KITITAS COUNTY

DEPARTMENT OF PUBLIC WORKS

MEMORANDUM

TO: All Staff
FROM: Public Works Planning Review Team
DATE: March 10, 2020
SUBJECT: BL-20-00004 The Pass Life

OWN BY: G. WEISER
 CHD BY: D. NELSON
 DATE: 7/2012
 SCALE: 1" = 50'
 JOB NO.: 11103
 SHEET: 1 OF 3

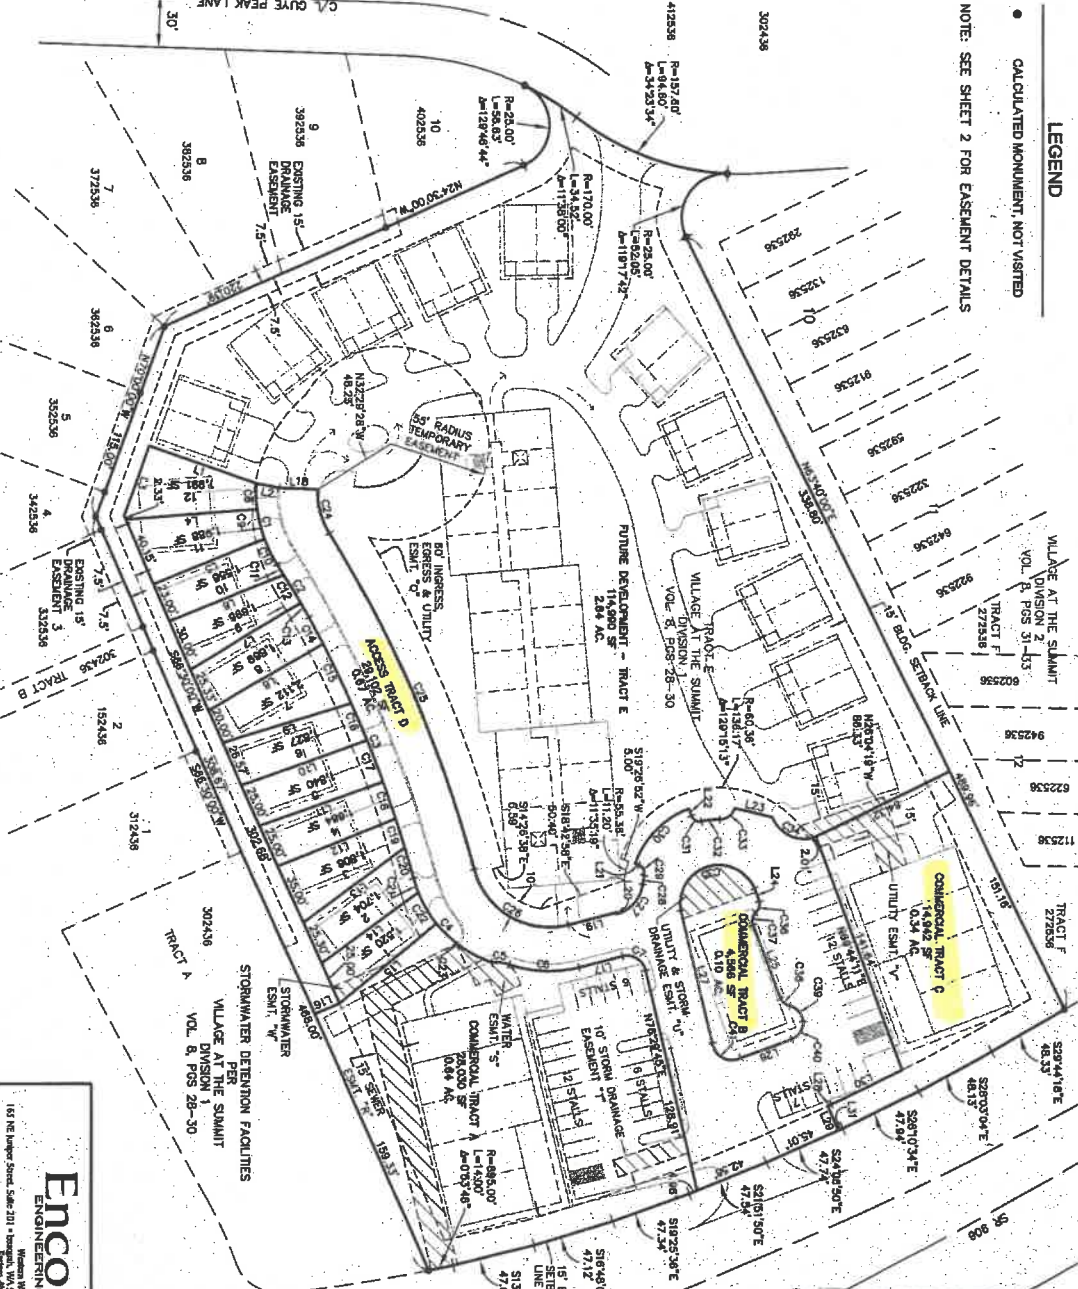
1. Private roads serving more than 14 parcels have a required 60-ft easement width for the entire roadway. Proposed parcels 3 and 4 impede the 60-ft width requirement for the entrance. The Southeast corner of access tract D does not meet the minimum 60-ft easement width.
